Our Ref: AW/81/20/HH
Your Ref:

Town & Country Planning Act 1990 (as amended)
Town & Country Planning (Development Management Procedure) (England) Order 2015
Application for Planning Permission for Works or Extension to a Dwelling

Development Single storey front extension
Location 6 Worcester Close Aldwick

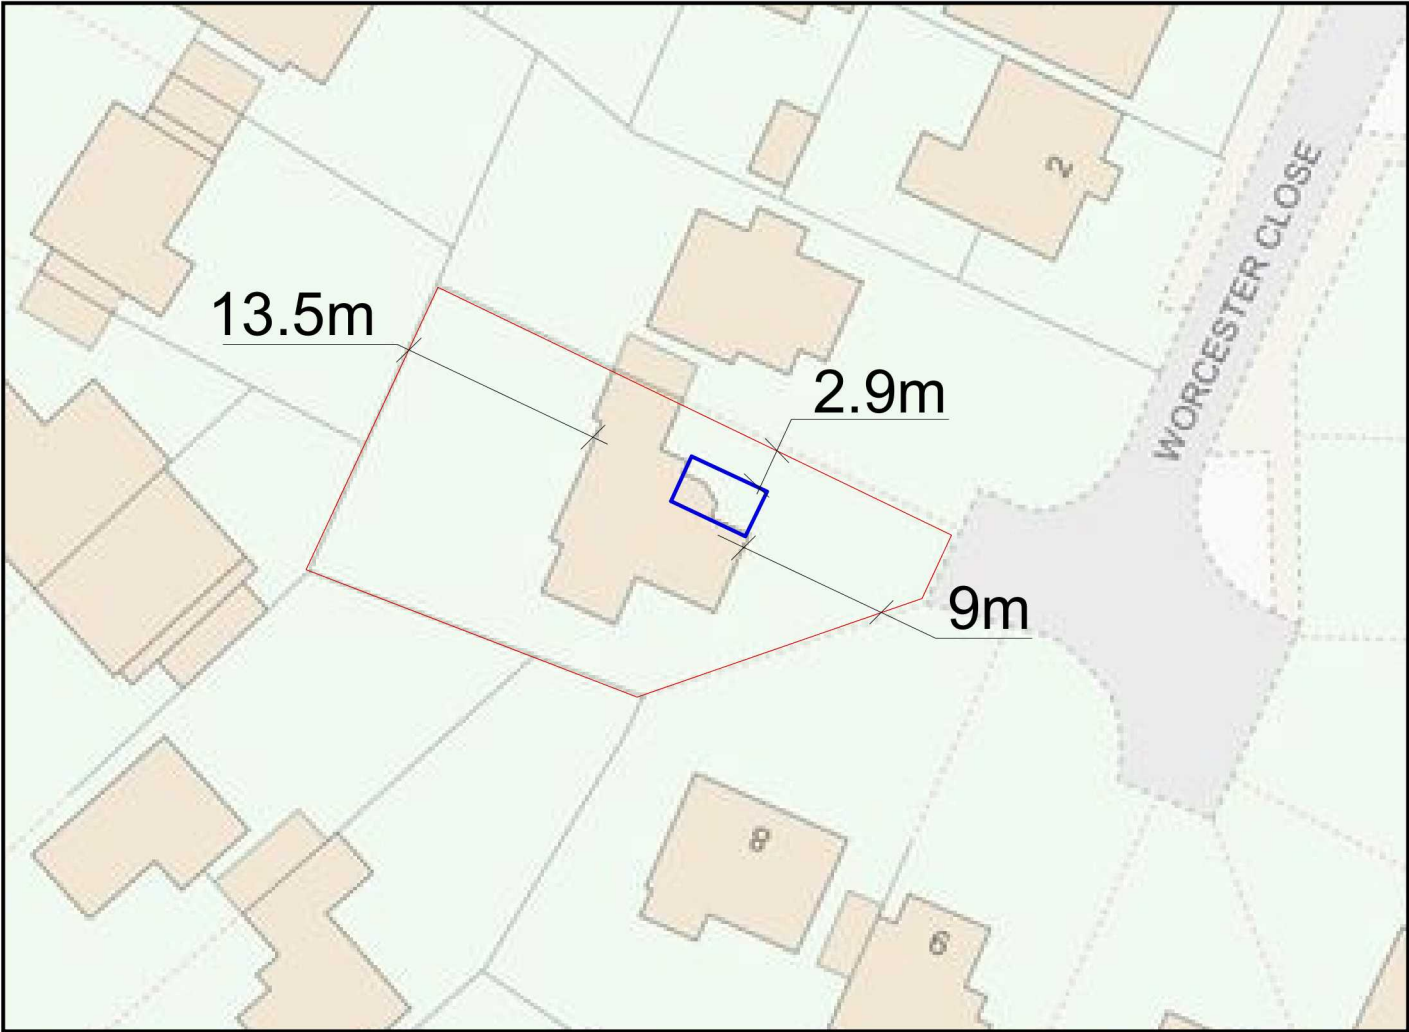
The scale stated on the Block Plan is incorrect. A block plan should be at a scale of 1:500 or 1:200.

The dimensions from the proposed extension to the boundary need to be shown on the Block Plan rather than the Location Plan.
